**From:** Anita Gardner <[REDACTED]>  
**Sent:** 17 May 2019 12:27  
**To:** Kevin Gale <Kevin@galowerbuild.co.uk>  
**Subject:** M/14/19/CLE - Land adjacent to 46 Sea Lane, Middleton

Proposed Drainage diversions 1:250 @a3

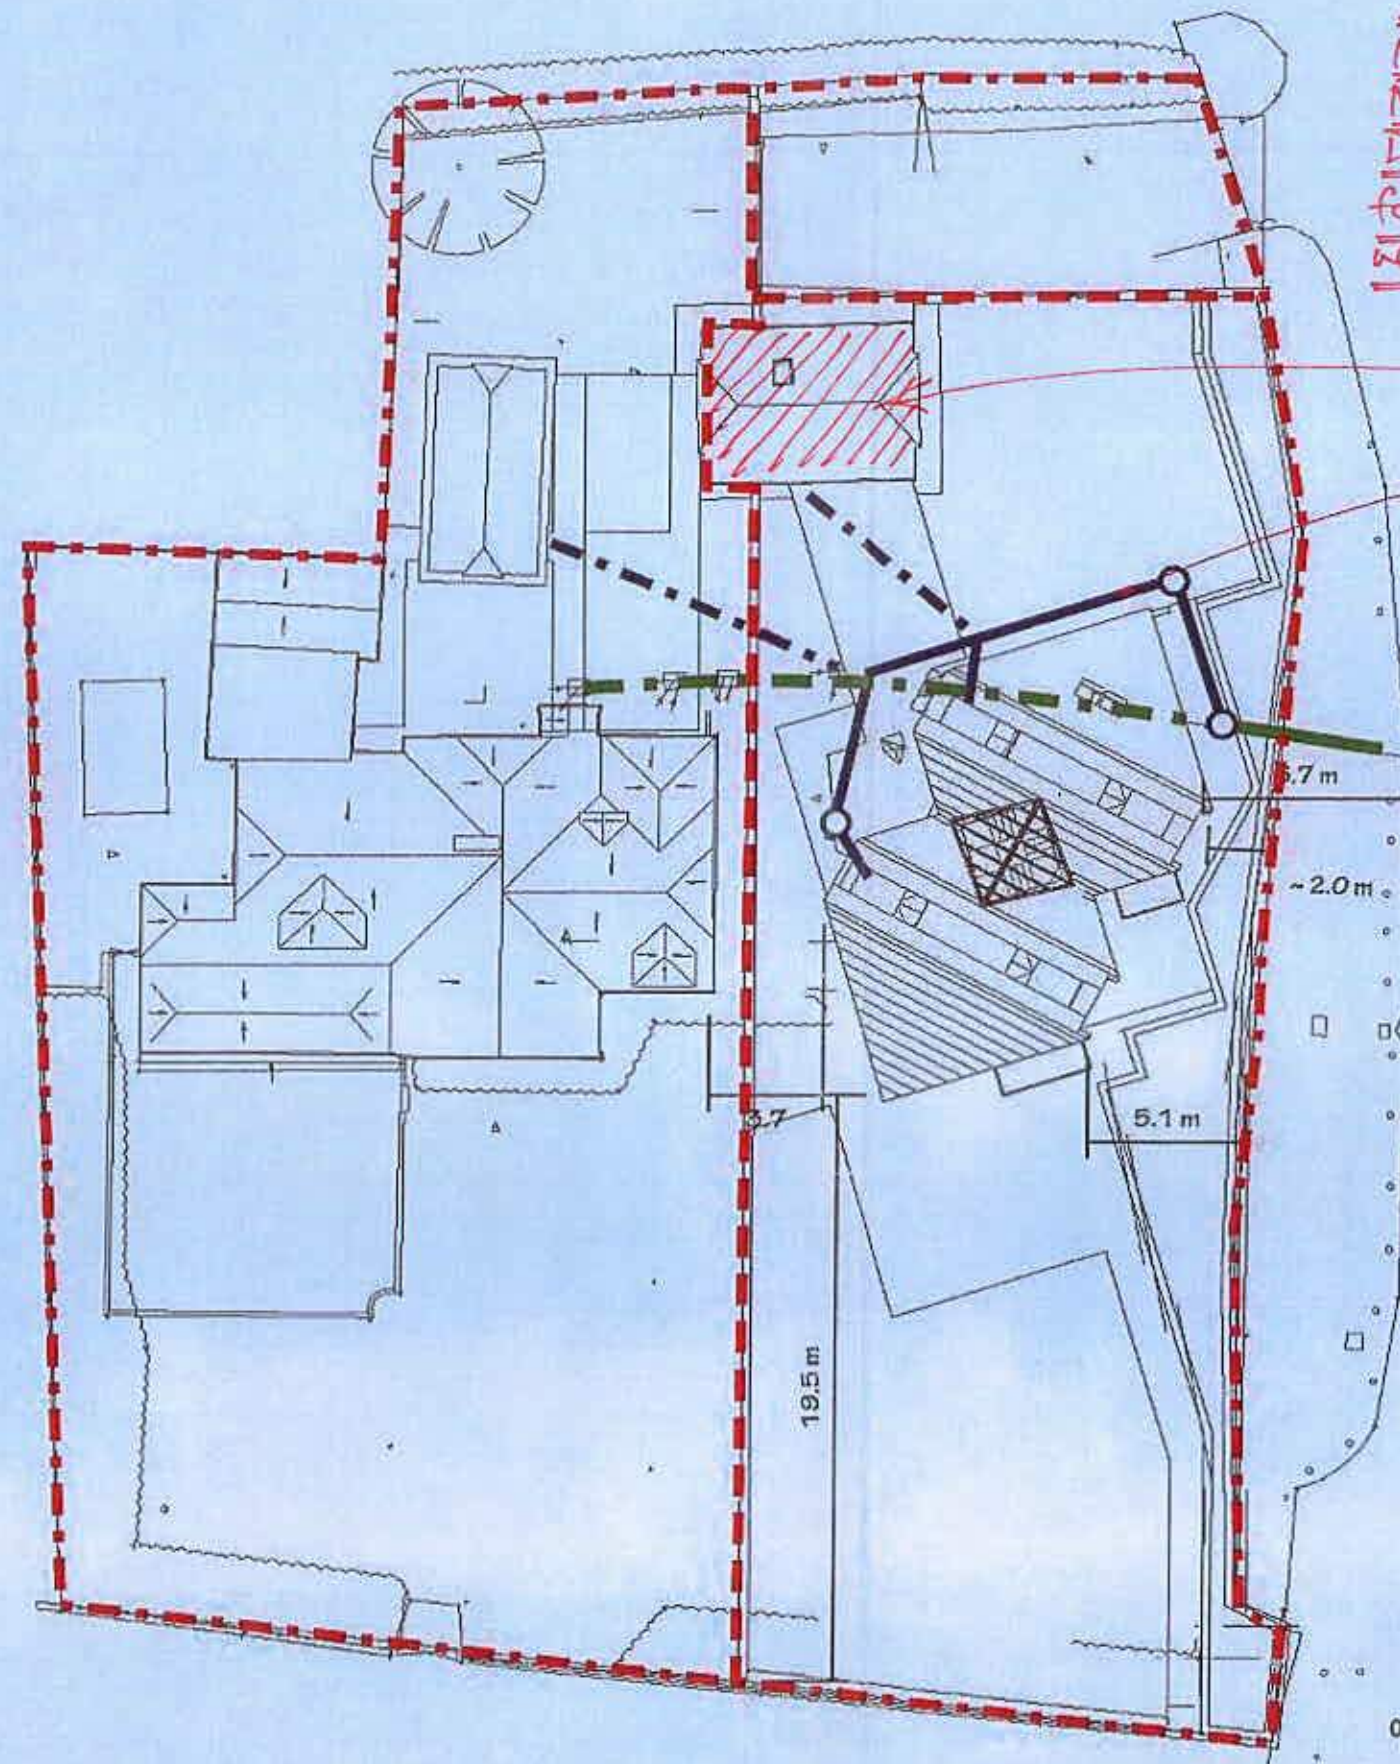
I note that some of the submitted plans dated 25-01-2016 include a note stating "all works complete" but this is not signed or dated and the Drainage diversion plan does not correctly indicate the extent of the garage/pool house which has been demolished. Please can you let me have revised plans to ensure the submitted information is not ambiguous. I would appreciate receipt within the next 10 days.
